SUBJECT: Engineering Review Comment  
Mountain View Electric Association Inc. (The Association)

**Project Name: Forest Heights Estates – Minor Subdivision**

**Project Number: MS206**

**Description:** Proposed development of 3 single family lots located east of Herring Rd. and north of Shoup Rd. in Township 12S, Range 65W, Section 09.

FOREST HEIGHTS ESTATES

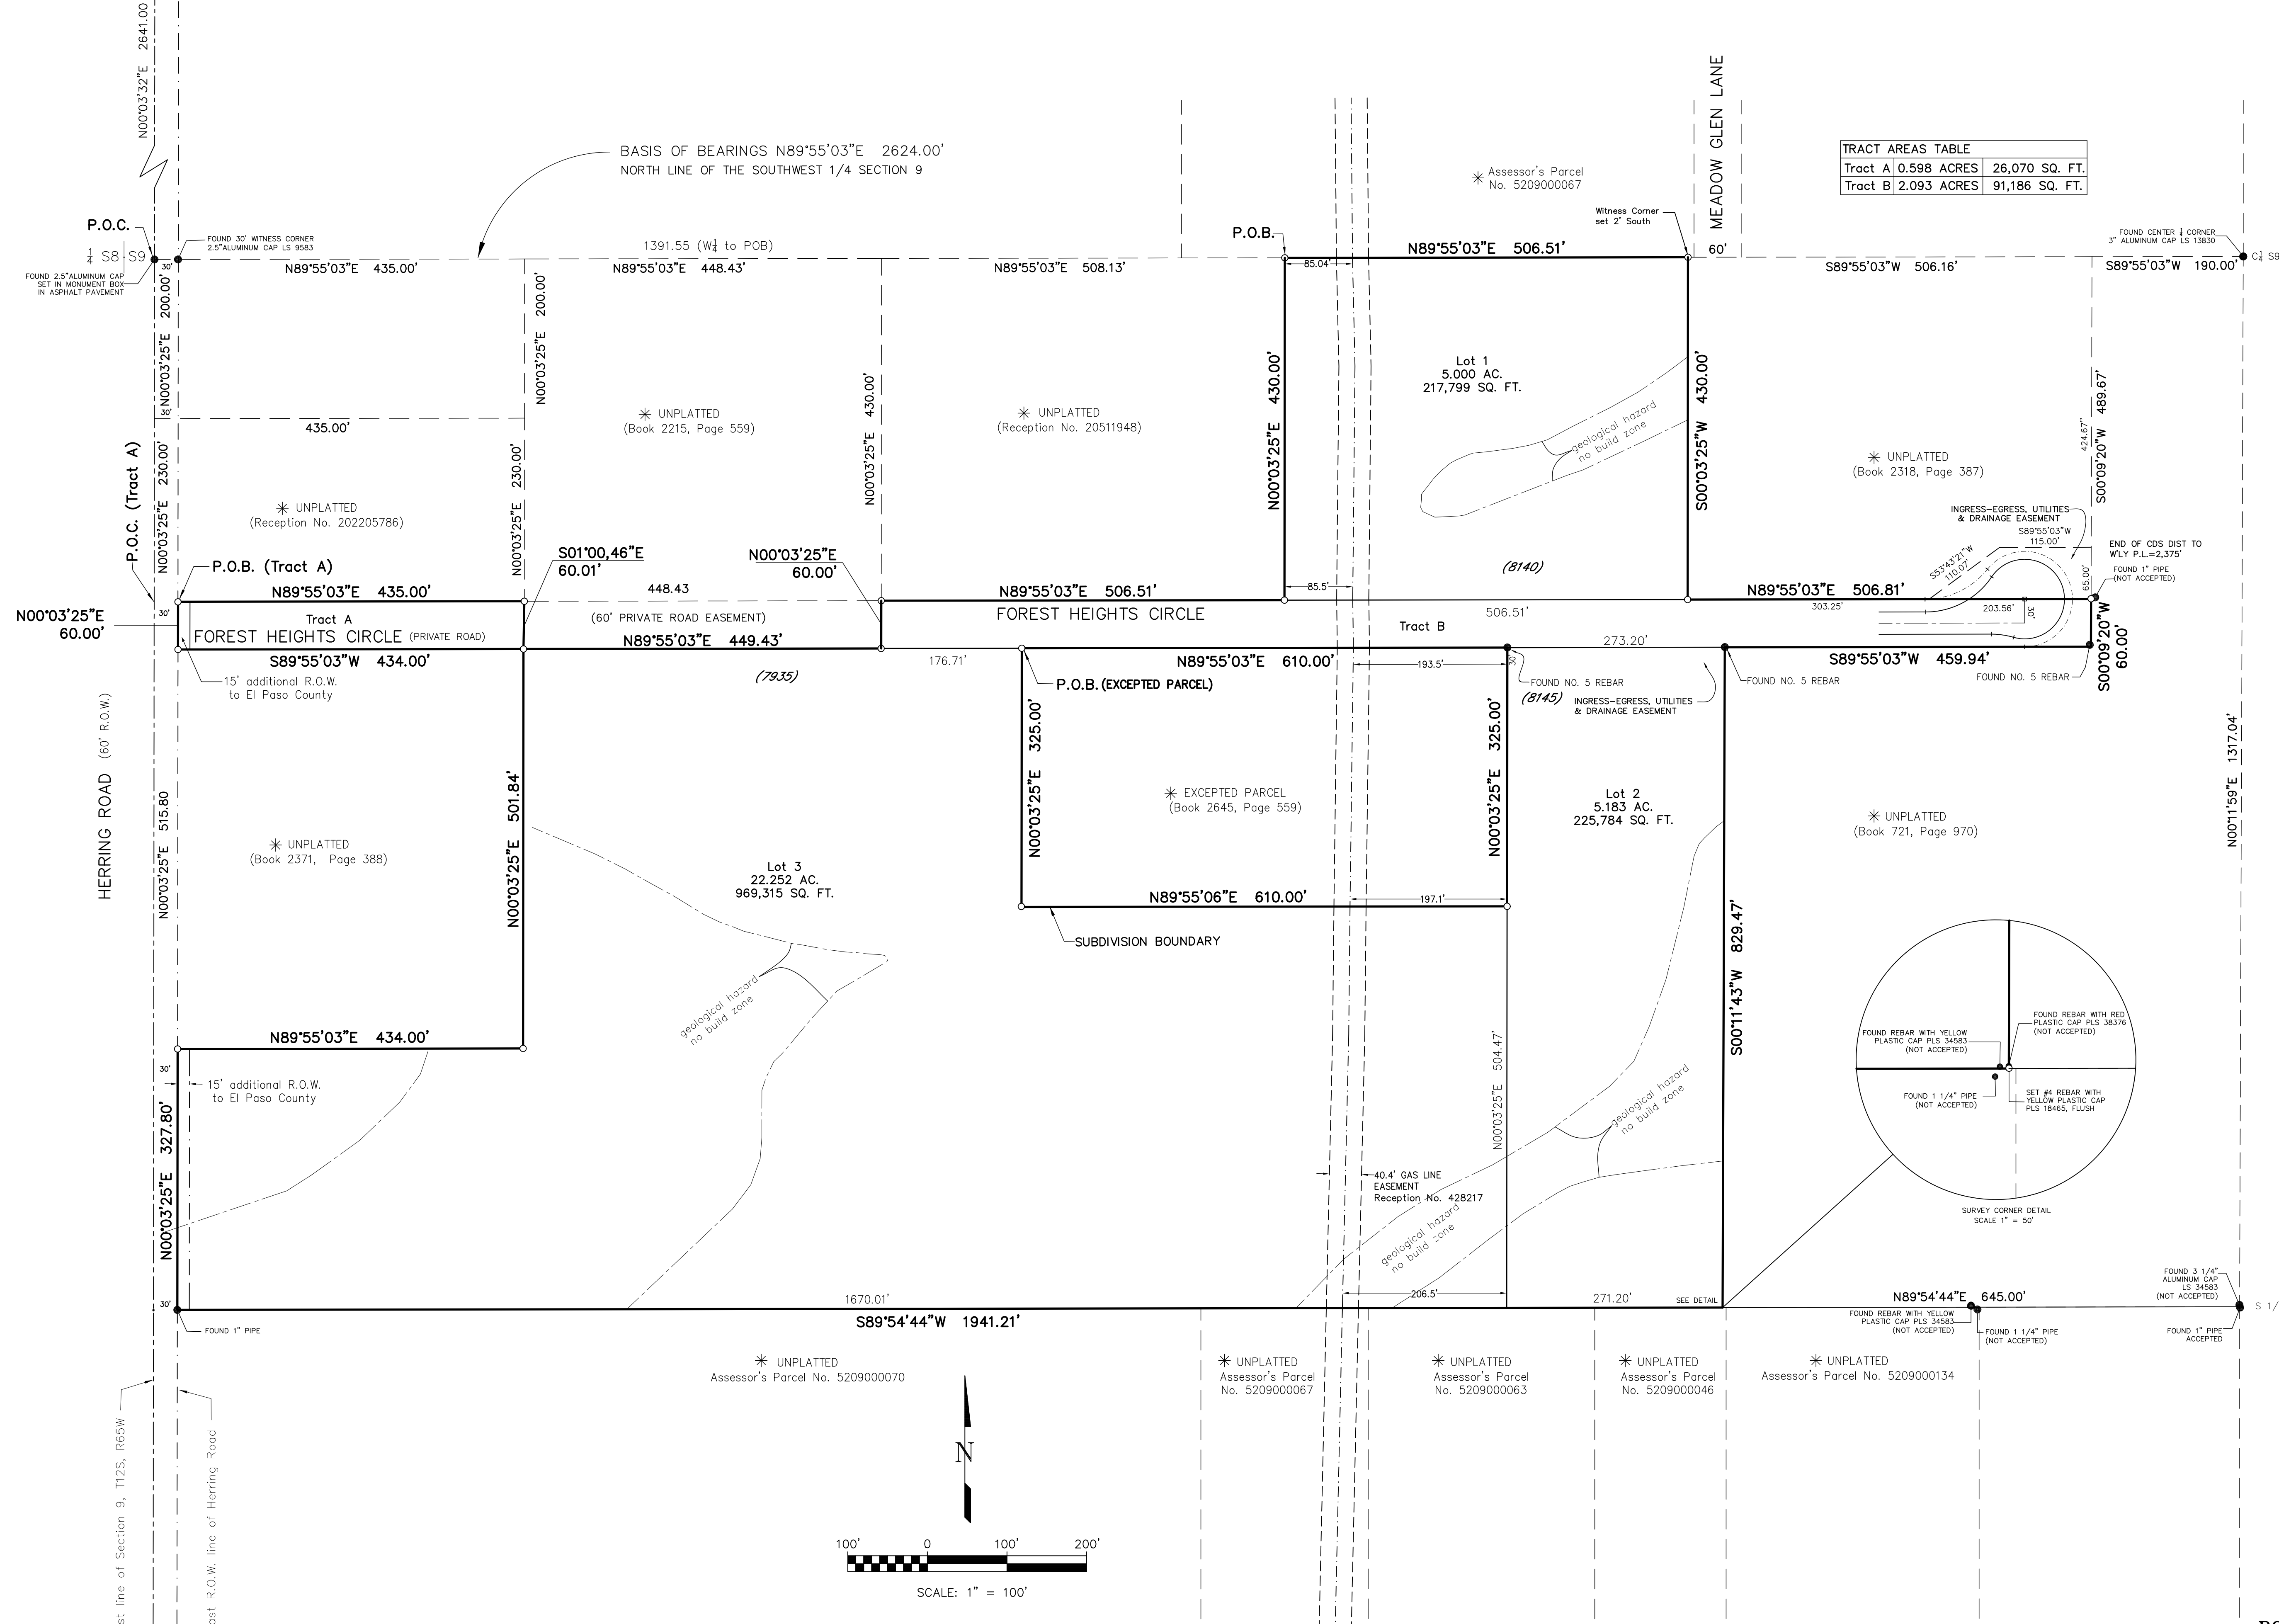
The Association requests a ten (10) foot front, side, and rear lot utility easement and all tracts, along with a twenty (20) foot exterior utility easement on the plat. The Association also requests the platting of the Association's existing facilities with easements on the plat. Additional easements may be required.
